Arboricultural Comment 2

**Sydney Fish Market – Site Accommodation,
Glebe NSW 2037**
Version 2

21st February 2022

Re: Arboricultural Comment 2 – Sydney Fish Market – Site Accommodation, Glebe NSW 2037

**Figure 4 | Proposed tree removal – T8** (source: Applicant's RTS)

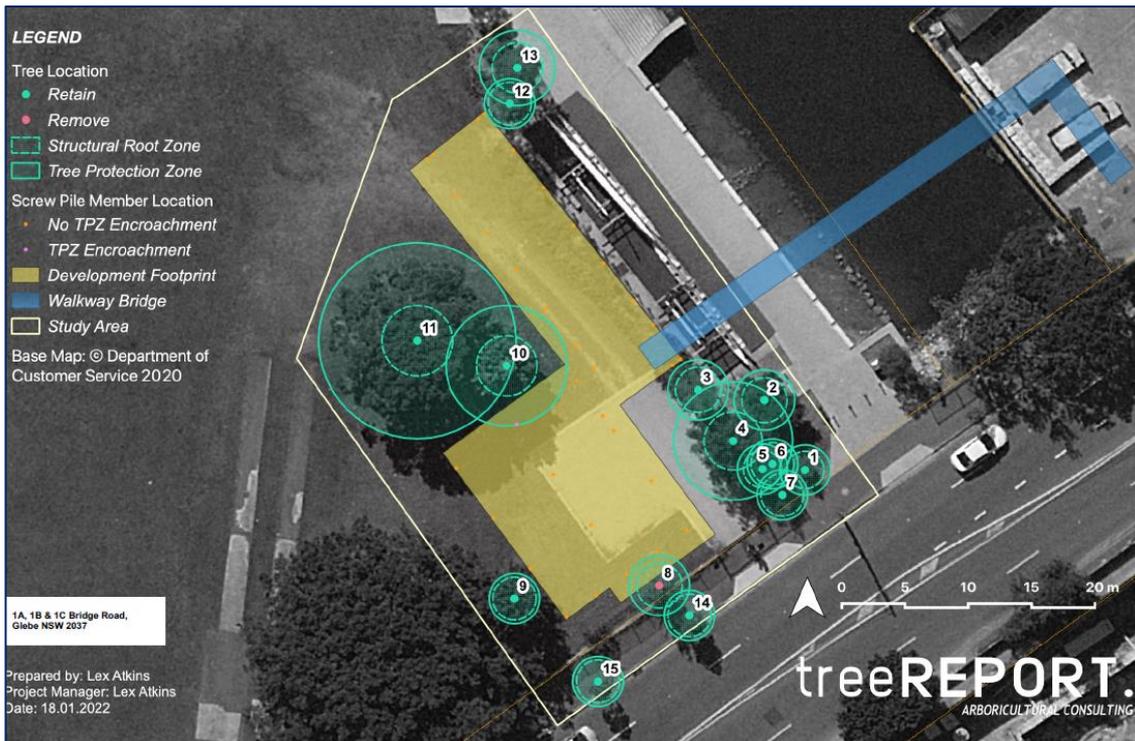
Council recommendation 1: *To retain T8, the proposed sewer connection should be relocated outside the Tree Protection Zone (TPZ) of all existing trees. Alternative installation methods for services, such as direction boring/drilling, or redirection of services shall be employed where large woody roots greater than 30mm diameter are encountered during the installation of any services adjacent to the specified TPZ.*

Response: Tree Report Pty Ltd has been advised by the Client that 'T8 will need to be removed as we are not permitted by Sydney Water to drill in a new connection point to the existing sewer main that runs through the school. The existing junction point that is located within T8's structural root zone is the only location we can connect our sewer to and thus cannot accommodate Council's suggestions. The other option for sewer is to place a sewer tank in the school carpark on ground floor, which will require daily pumpout with a collection truck. This is not desirable as students will be exposed to foul odours from the tank, while a pumpout truck will need to enter school grounds daily.'

Furthermore, Subject Tree **id.8** is of low retention value, and offset replacement replanting, to compensate for the loss of the tree, has been proposed in the AIA report (refer to Section 6 – Recommendations, page 13).
